**Transport
for NSW**

**Response to Stages 1A and 2, Site 43/44 Mixed Commercial and Retail Development,
Sydney Olympic Park (SSD 12_5676 and SSD12_5677)**

TfNSW has reviewed the documents *Traffic Impact Assessment, Mixed-Use Commercial and Retail Development, Stage 1A – 6 Australia Avenue, Sydney Olympic Park & Traffic Impact Assessment, Mixed-Use Commercial and Retail Development, Stage 2 – 2 Herb Elliot Avenue, Sydney Olympic Park* dated 14 May 2013 prepared by Traffix.

drawing title  
Ground Floor Basement Access & Loading Dock  
Access

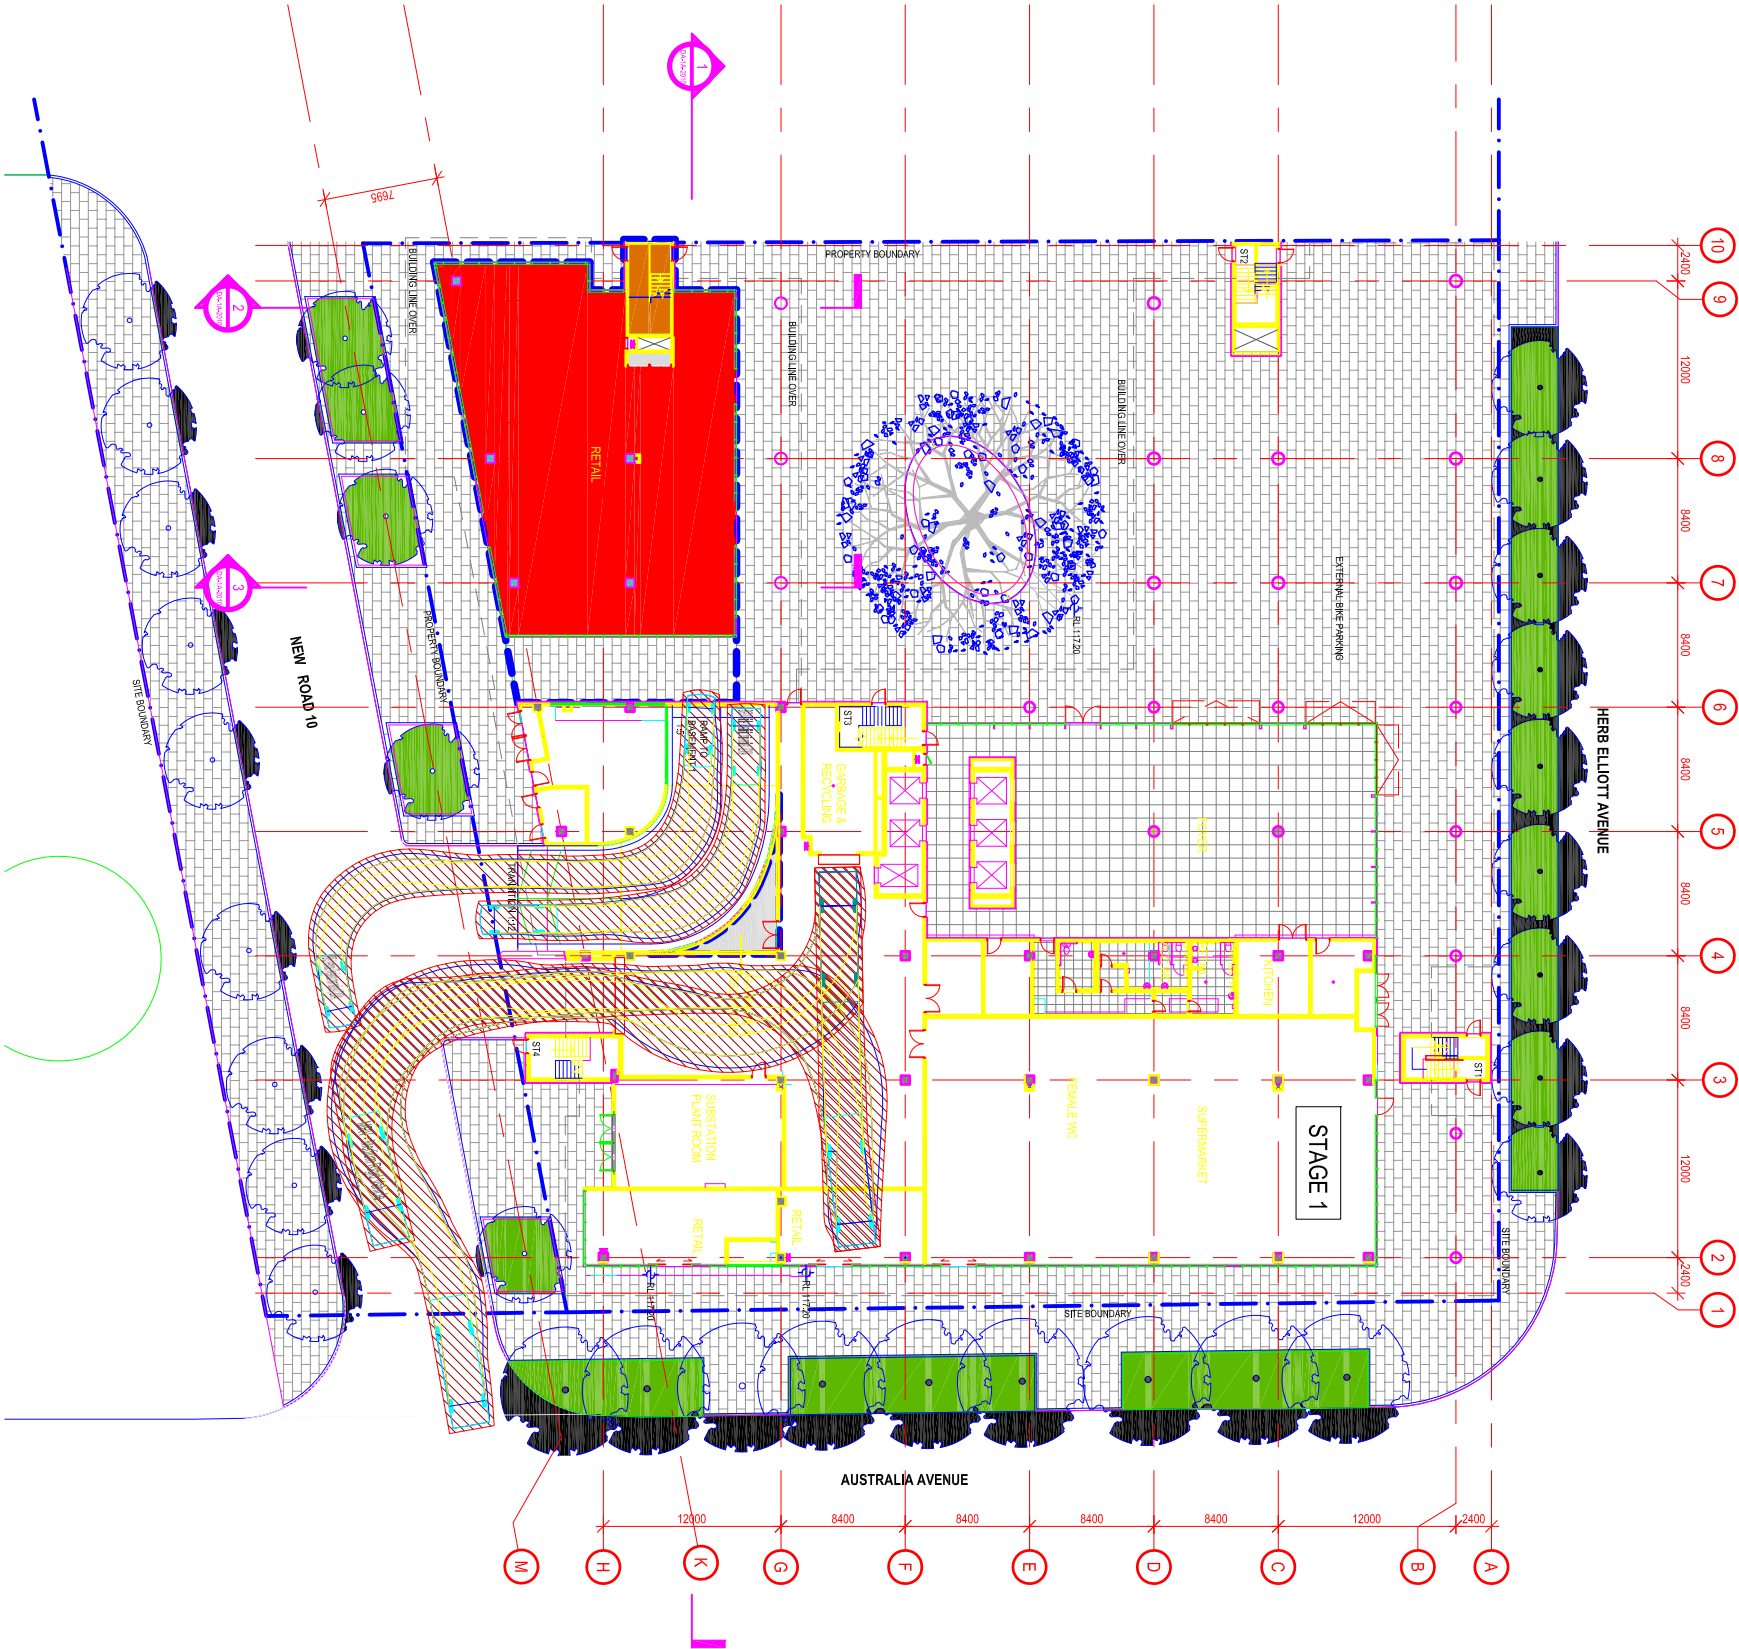
- TfNSW/RMS requests that the layout of the proposed car parking areas associated with the proposed developments (including, driveways, grades, turn paths, sight distance requirements, aisle widths, aisle lengths, and parking bay dimensions) be in accordance with AS 2890 parts 1, 2 and 6.
